Drawing No. H20017 - 250 Rev. P2

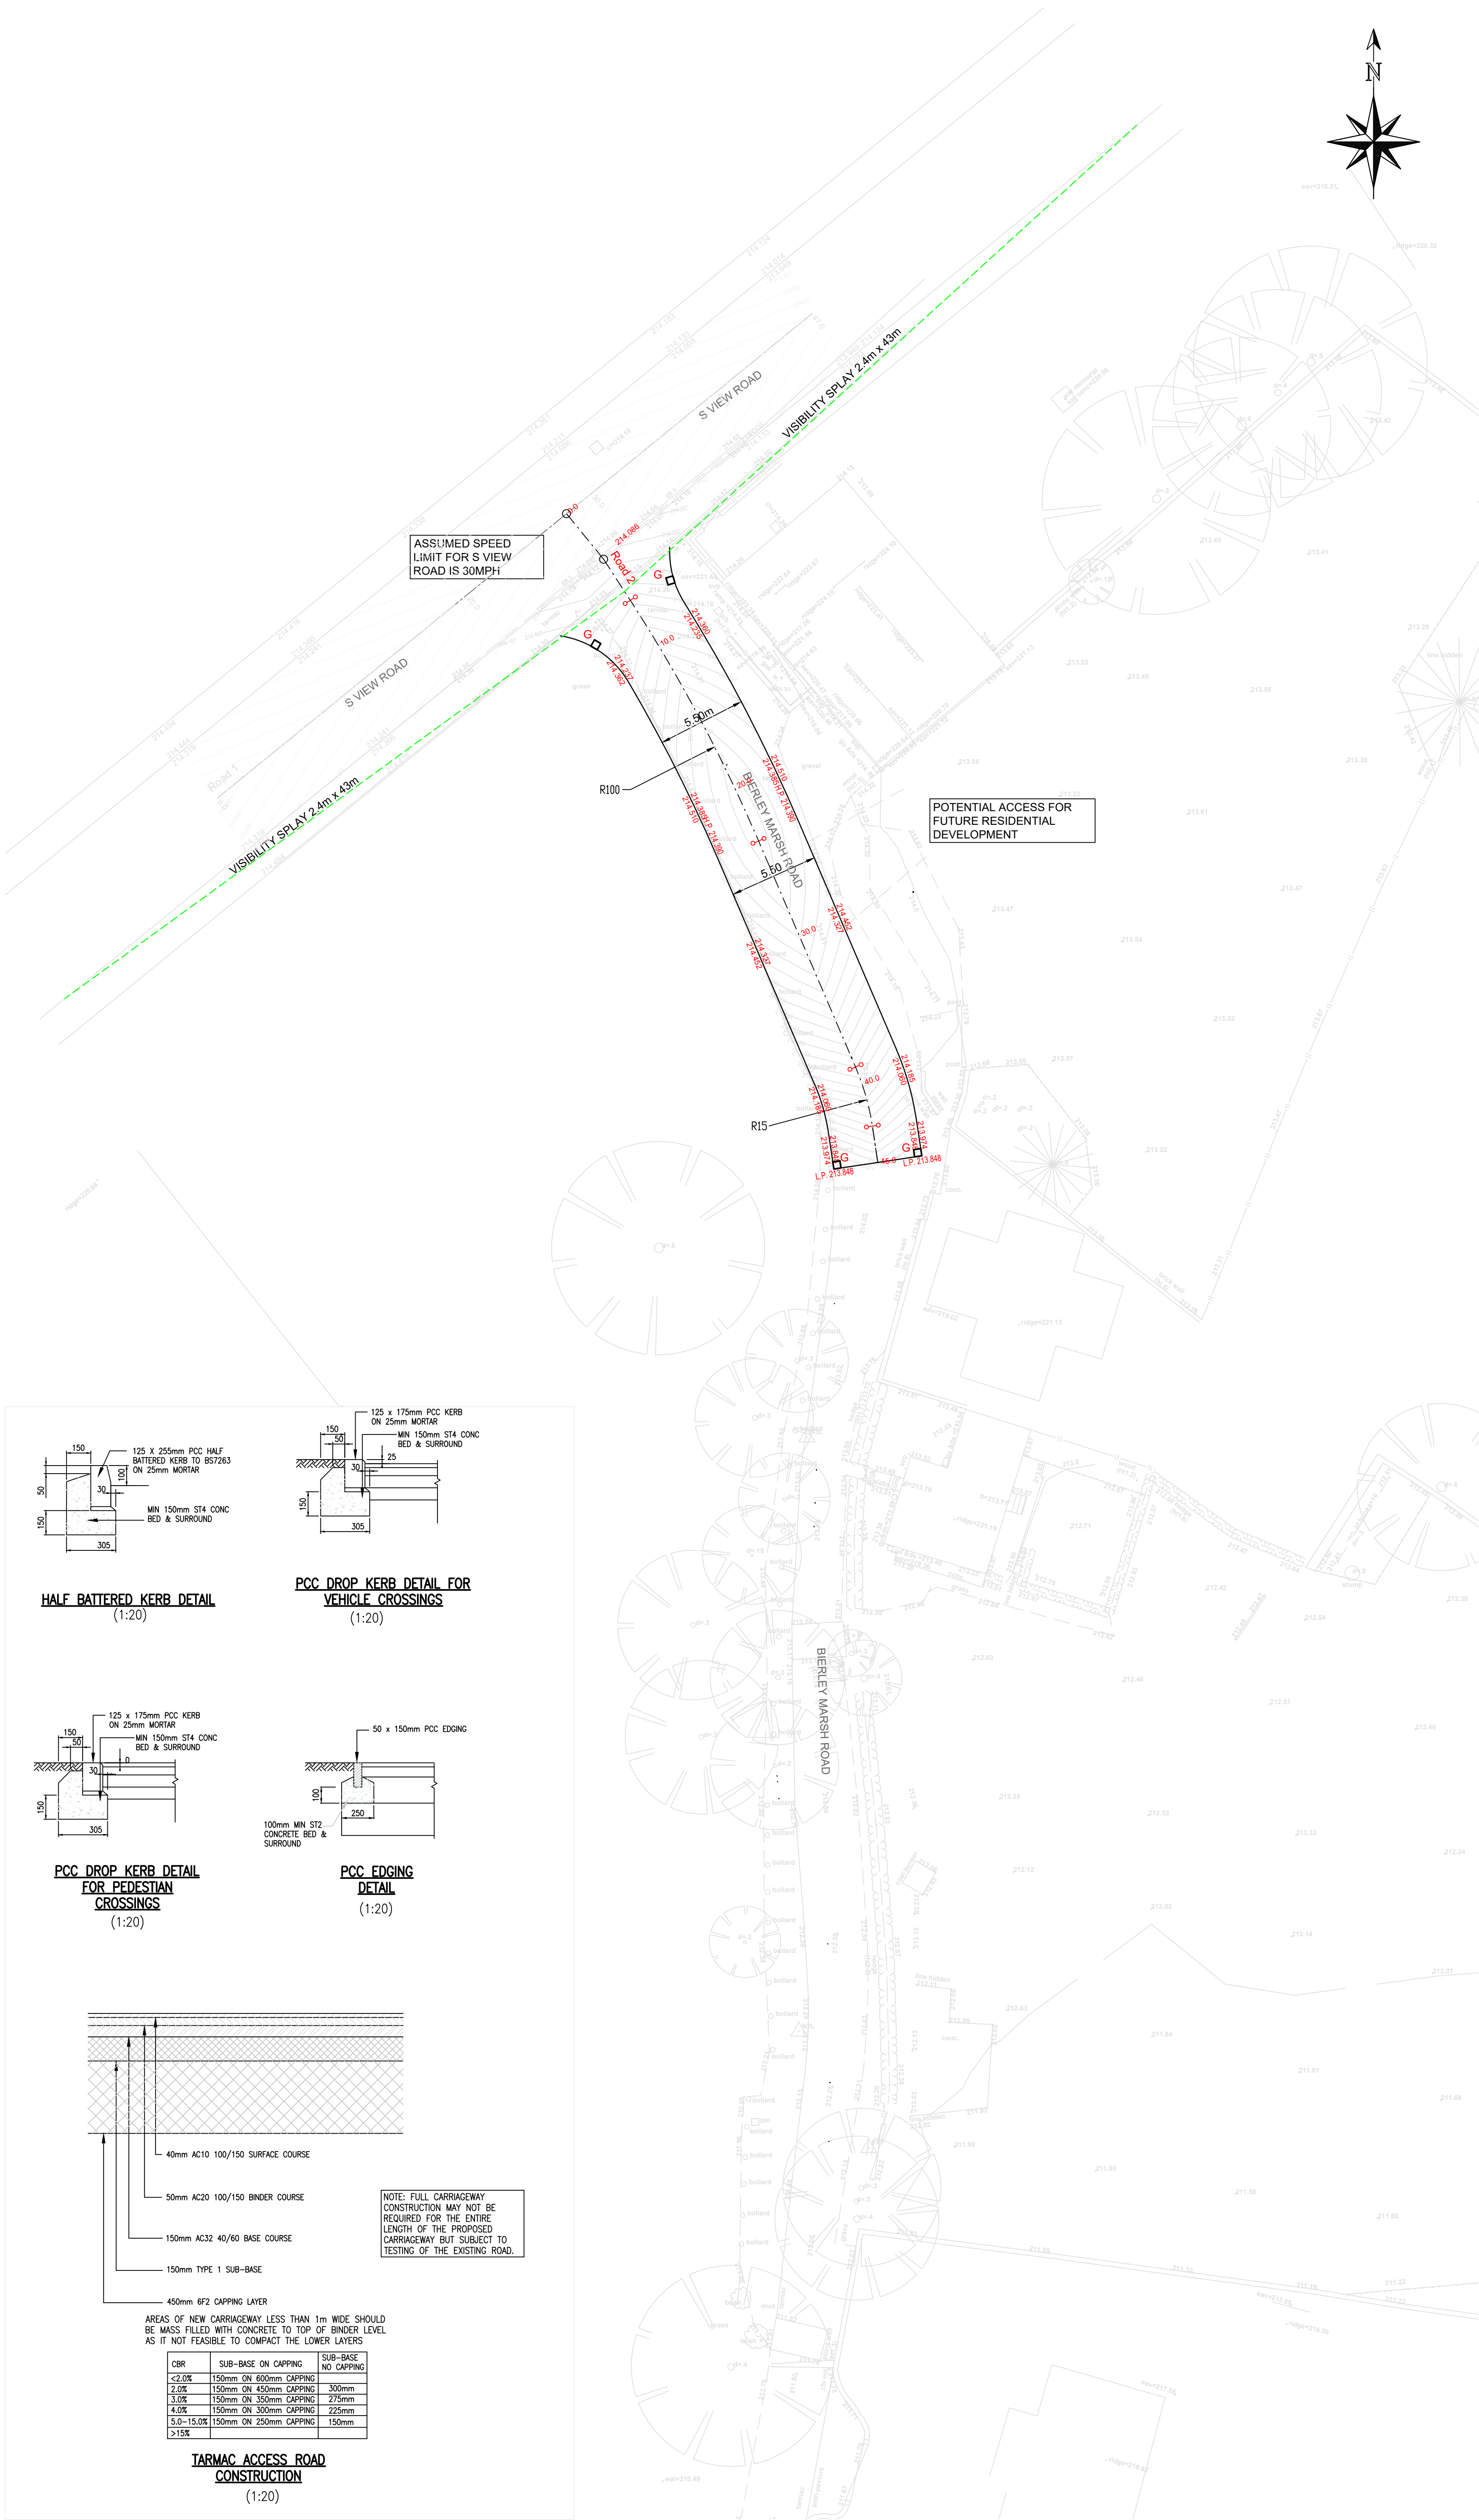
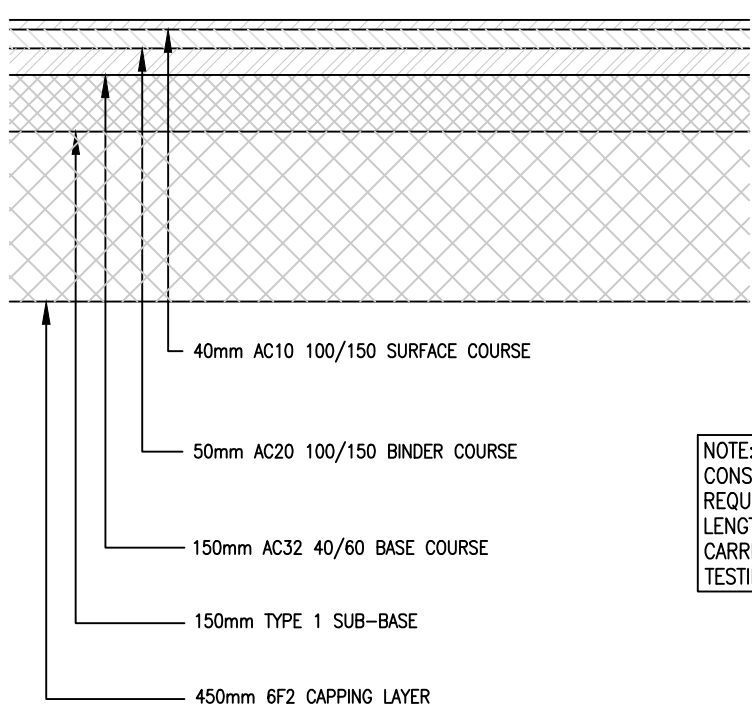
- 1) How would Kirklees assess if an adoption offered public benefit?
- 2) How practical is it to only adopt only 45m (total c. 250m) of Bierley Marsh?
 - a. how would an interface be managed with SPE 6/20 given traffic restriction causing an interface onto part of the footpath that has restrictions and that any vehicles continuing onto the unadopted footpath would be potentially a traffic offence.

- a. Any approval given under this application will be piggy backed to connect a larger 2nd field further down Bierley Maesh
 - b. How would it be proposed to make Bierley Marsh capable of sustaining two-way traffic. Bierley Marsh has many pinch points and appears for much of its length as a 10ft wide

- 9)
 - Matters below would not seem acceptable:
 - a. construction of kerbing and transition from adopted road to footpath
 - b. The developers design does not

- g. The developer has stated that we have possibly giving the impression shielded from sight of all vehicles.
 - i. Turning circles for utility and emergency services are shown outside the site and encroach on common land and land

Partial adoption, 45m of the 250m crescent, would create an unmanageable interface with a public footpath with traffic restrictions. How would Kirklees propose this interface be managed, if Adoption proposals were approved?
